COMMUNITY DEVELOPMENT DEPARTMENT
501 Delta Avenue ♦ Marysville, WA 98270 ♦ (360) 363-8000

Re: Stack Short Plat (SP22006) 2nd Submittal Technical Review Comments

RE: Stack Short Plat, File# SP22-006
5 Lot Short Plat
3807 122nd Street NE & Parcel # 30050900202200

**STACK DESIGN & CONSTRUCTION, LLC**  
**STACK SHORT PLAT**  
PRELIMINARY WATER AND SEWER PLAN

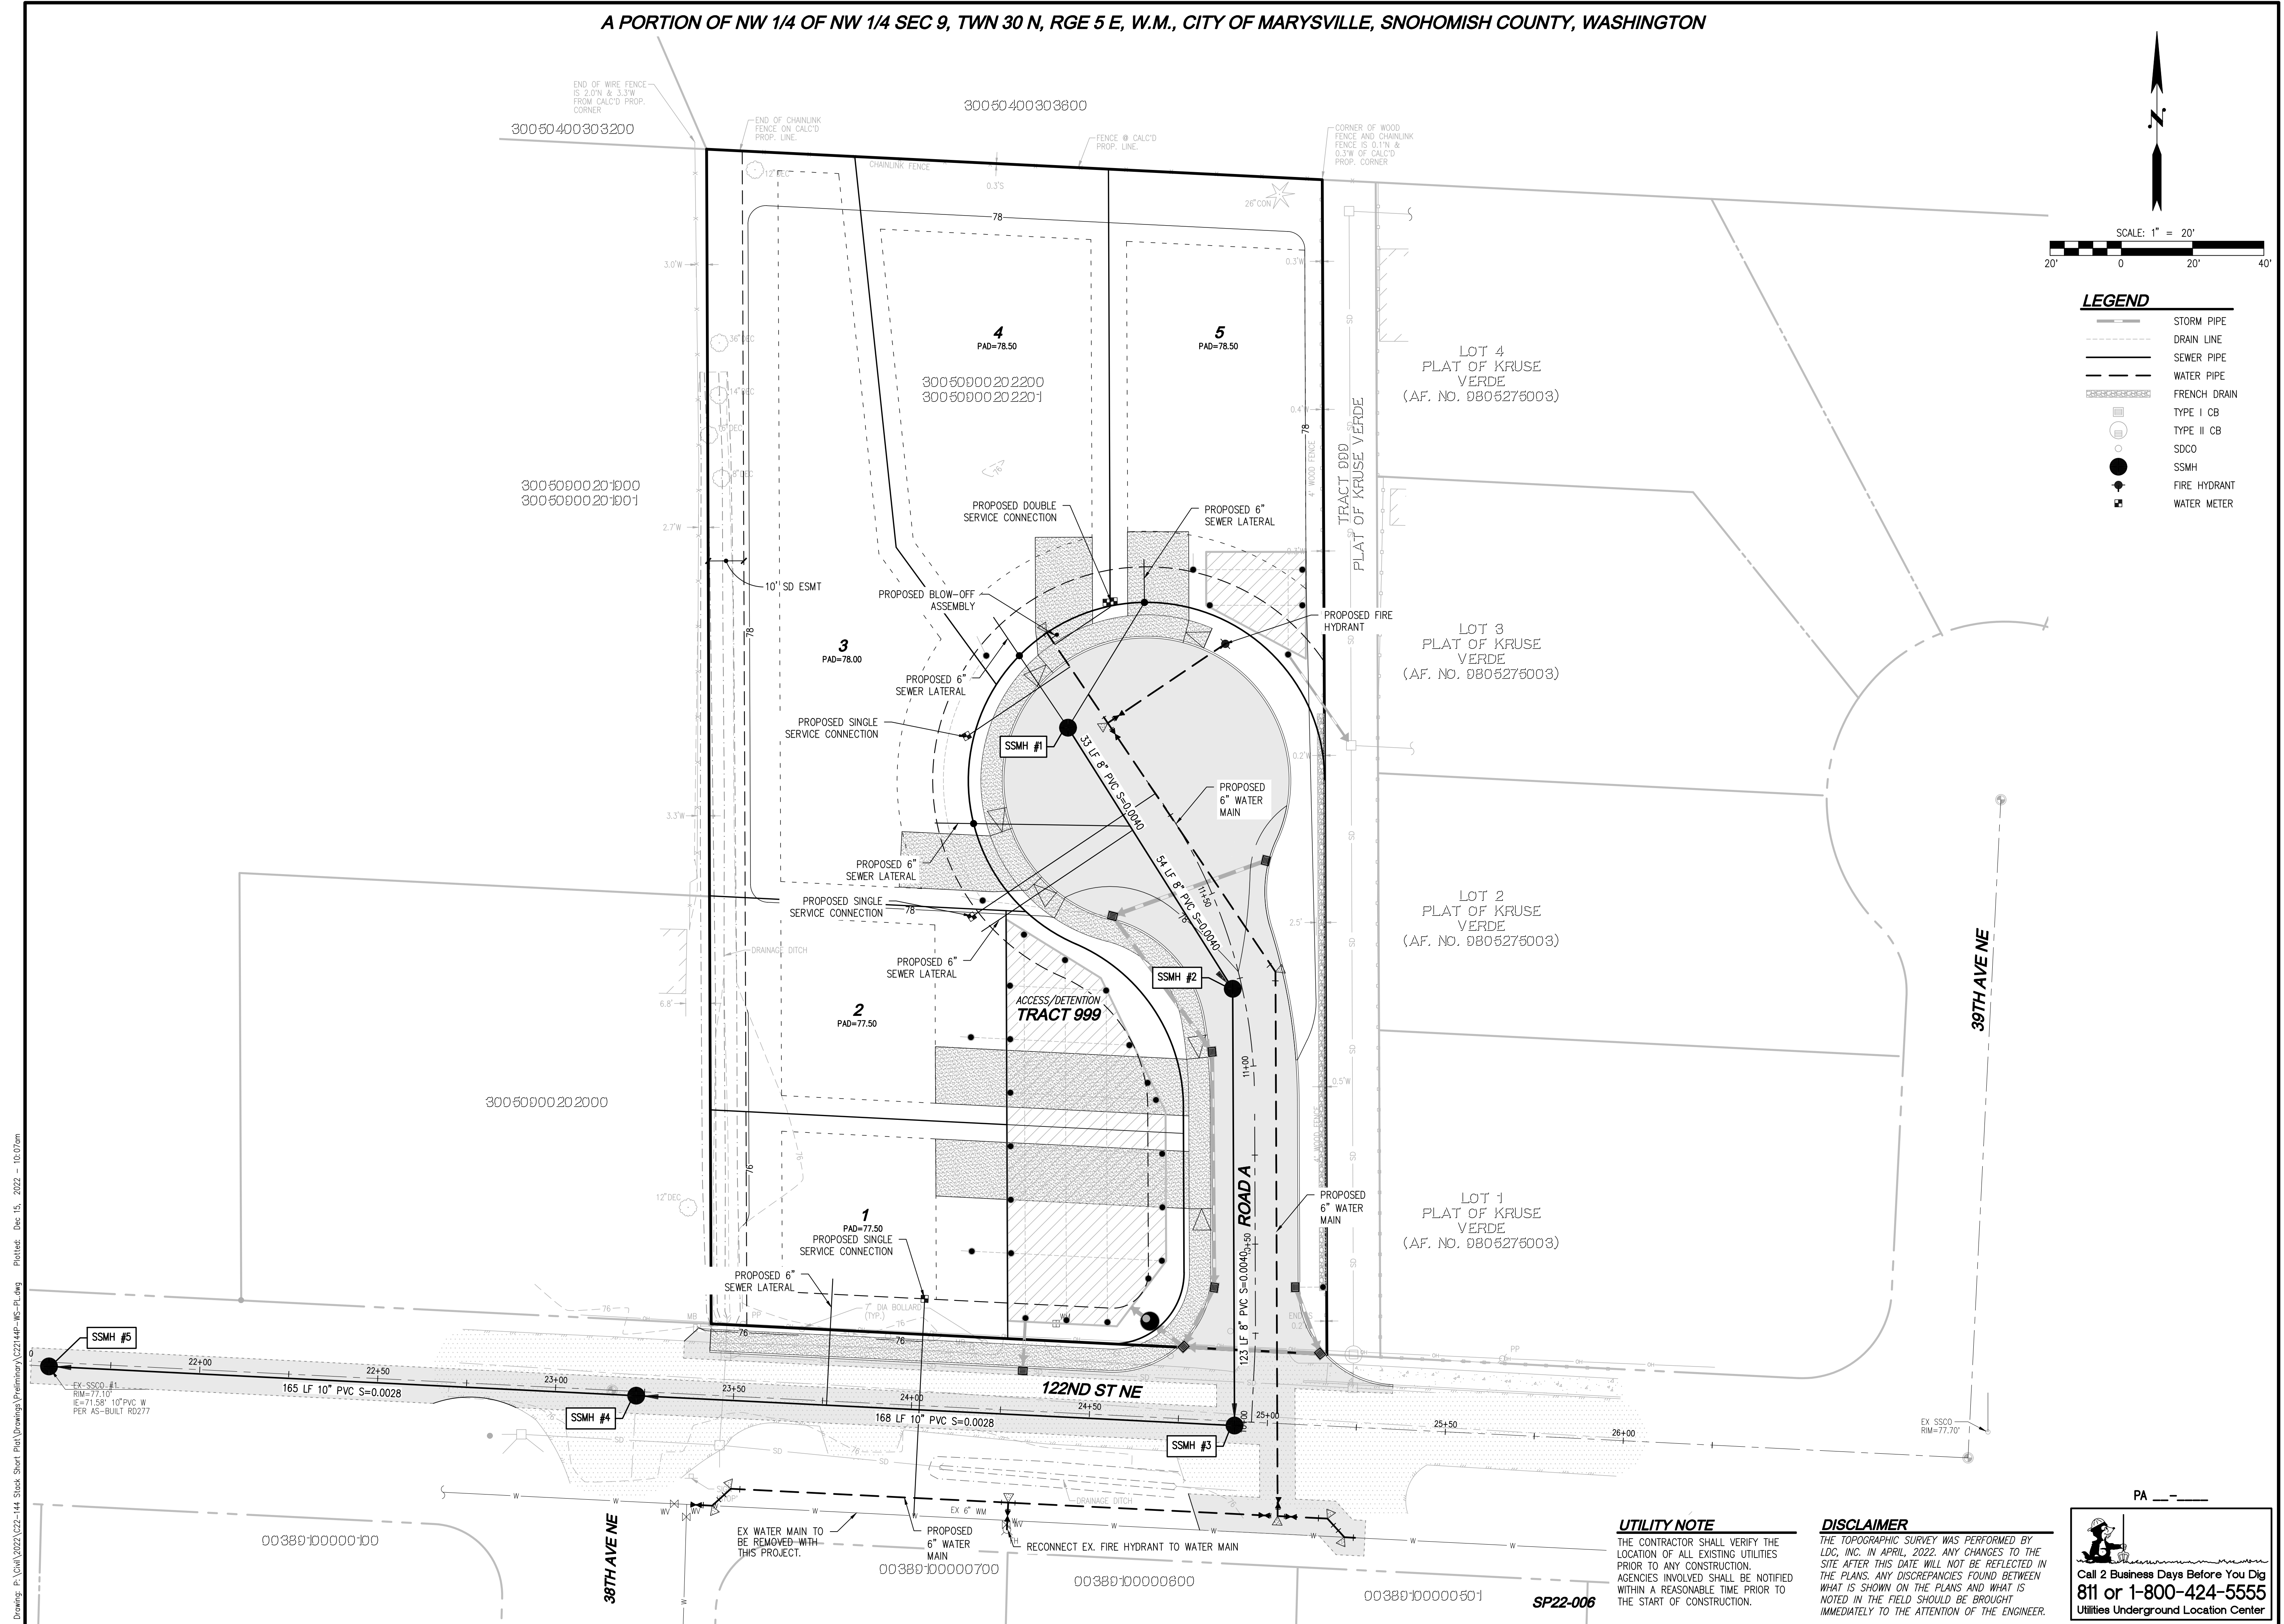
1. Per MMC 14.03.250, utilities are to be extended along the street frontages of the proposed project.
 - a. Sewer will need to be extended across the projects frontage.

- b. Watermain currently fronts the project, it may need to be upgraded to an 8 inch line.
2. **Frontage Improvements:** Frontage improvements are required per MMC 12.02A.090 on all projects. Frontage improvements are described as curbs, gutters, and sidewalks; underground storm drainage facilities; patching the street from its preexisting edge to the new curb line; and overlayment of the existing public street to its centerline.

1. Proposed new water main installed is shown as 6". New water main should be 8" in accordance with Design and Construction Standards 2-050 part B;
2. Proposed single service connection for Lot 1 is shown connected to old water main;
3. Design and Construction Standards 2-090 part A state that all new connections shall be single meter services. Suggest moving service line for Lot 4 to left side of driveway to allow for perpendicular connection to water main;
4. Water details not shown;
5. Replace proposed new 6" water main going into plat with 8" water main in accordance with Design and Construction Standards 2-050 part C.

SP-01
 SHEET 3 OF 7

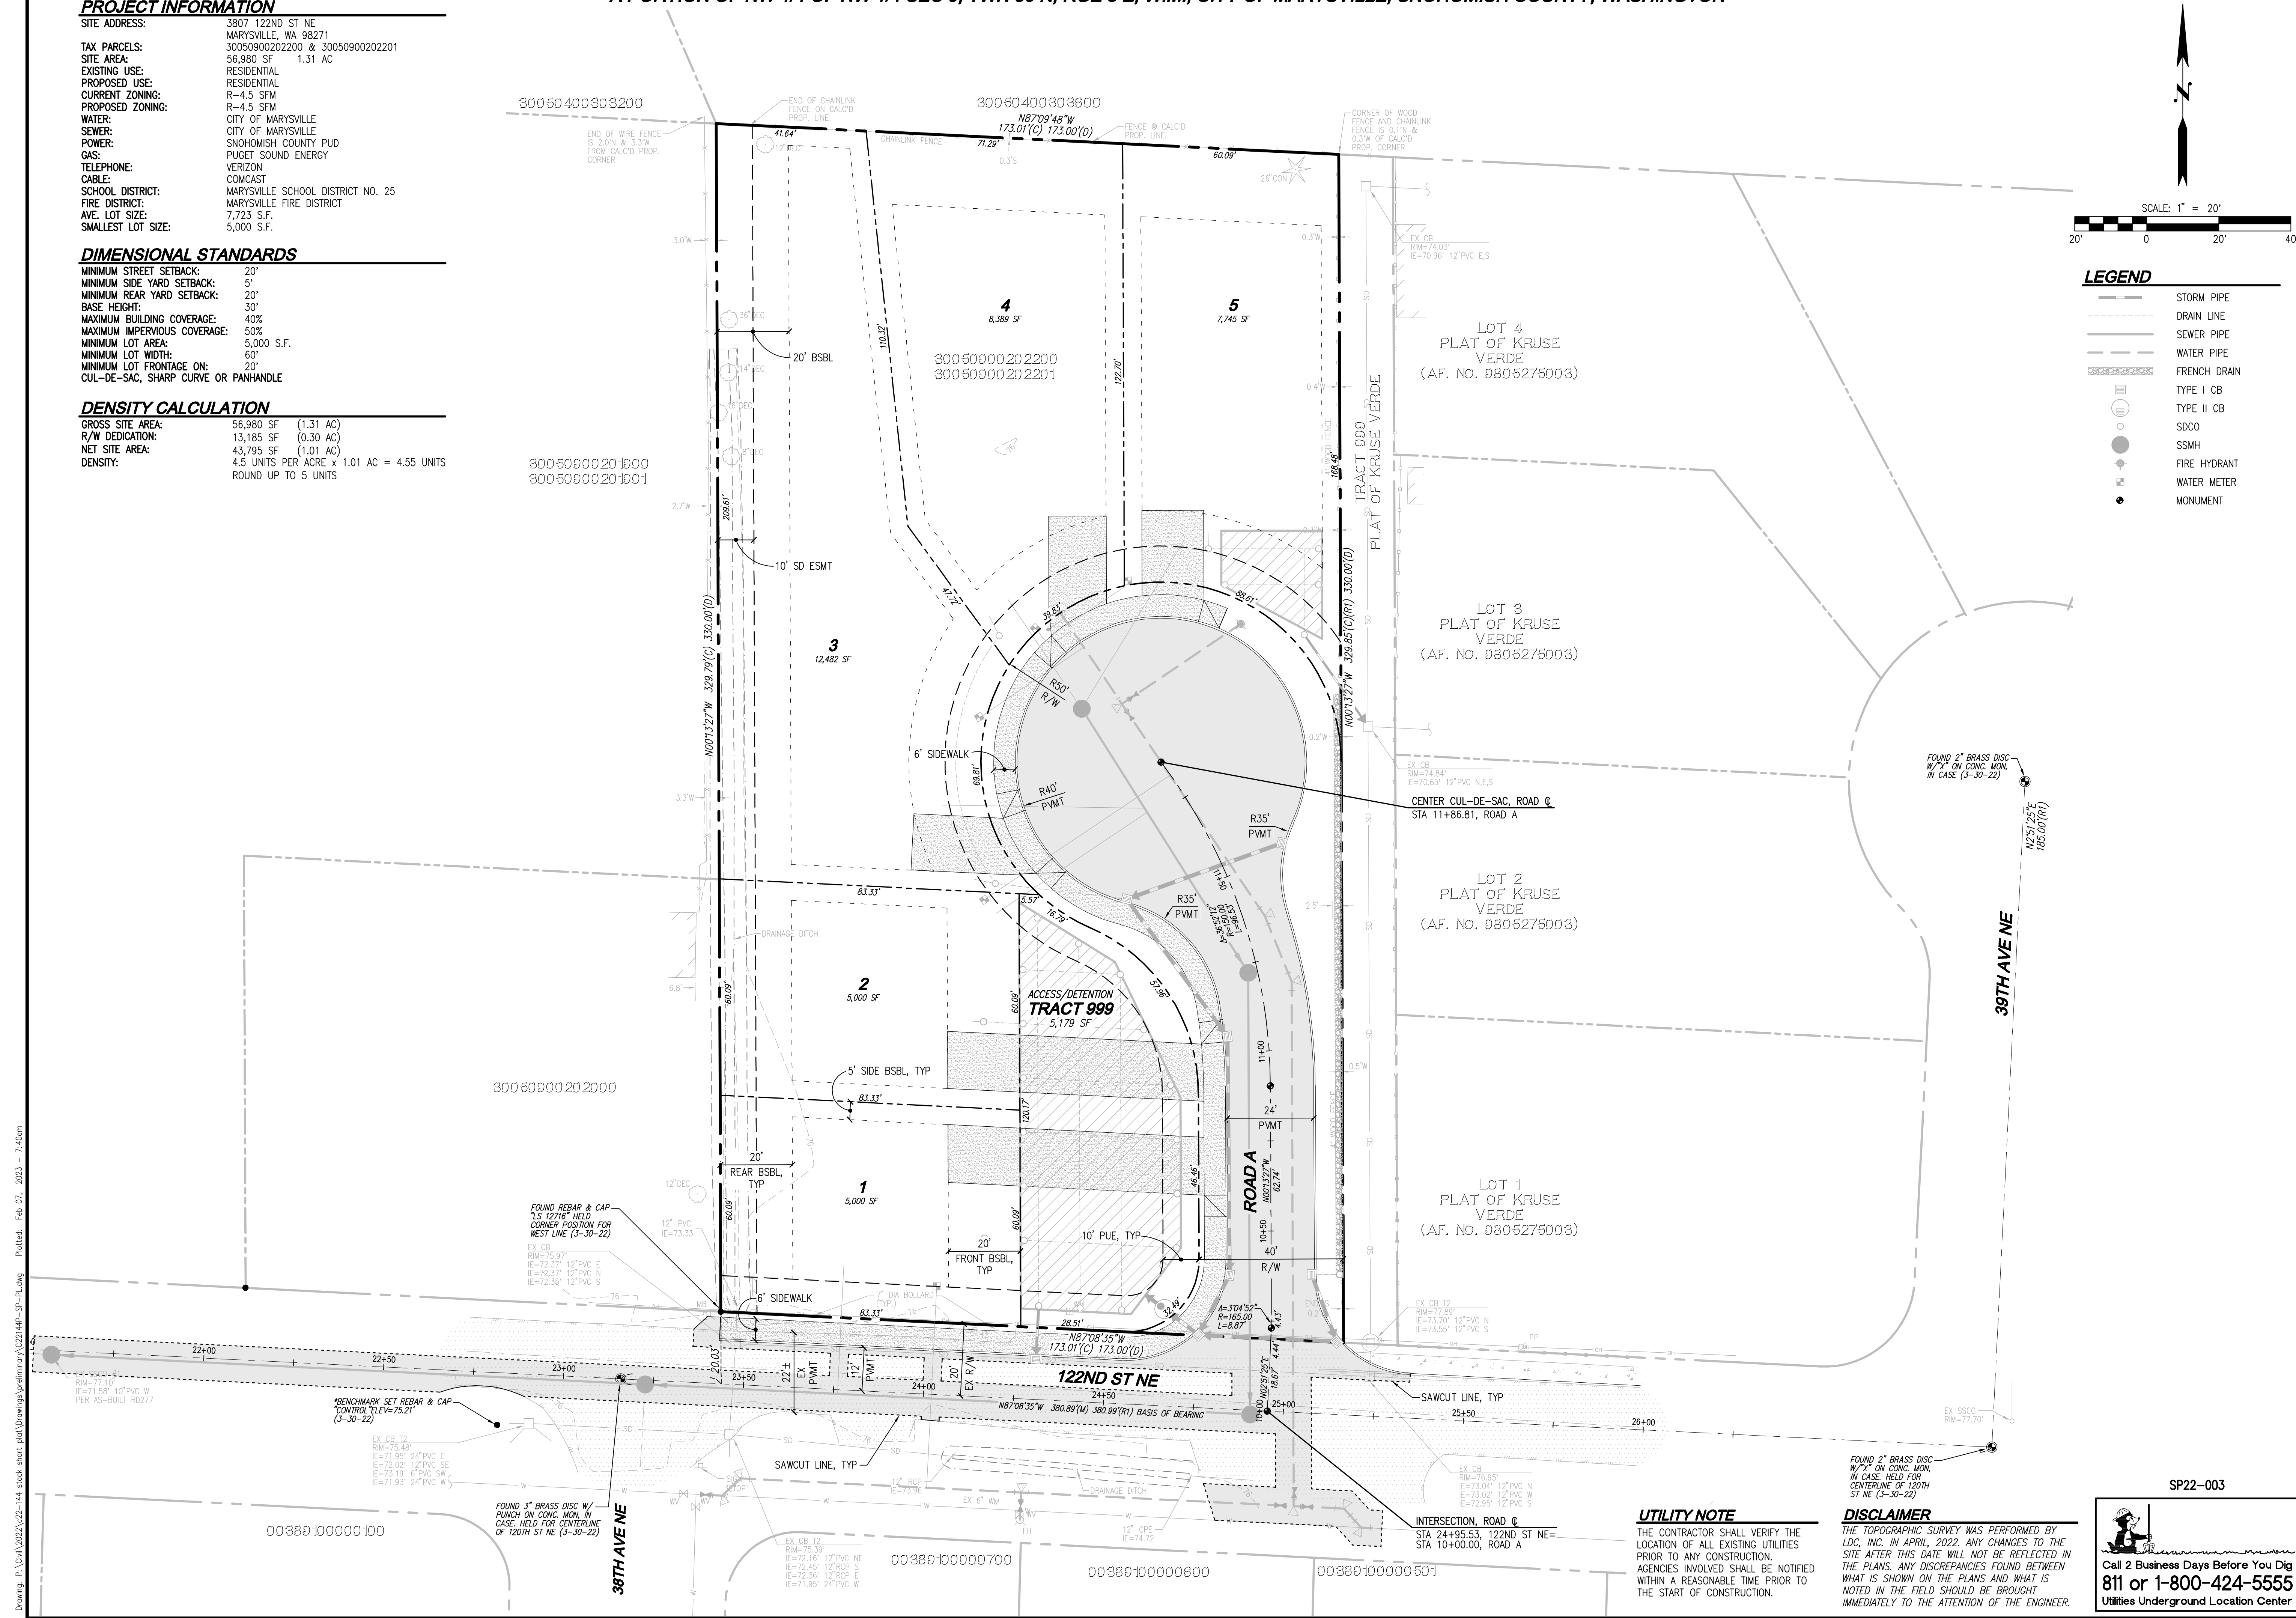
TRC2 Comment: The entirety of Tract 999 will be required to be relocated west behind Lots 1 & 2 adjacent to APN 30050900202000, not the overflow path exclusively. Tract 999 shall not include private driveway access. Maintenance access to Tract 999 will be allowed to be accessed off of 122nd Street NE.
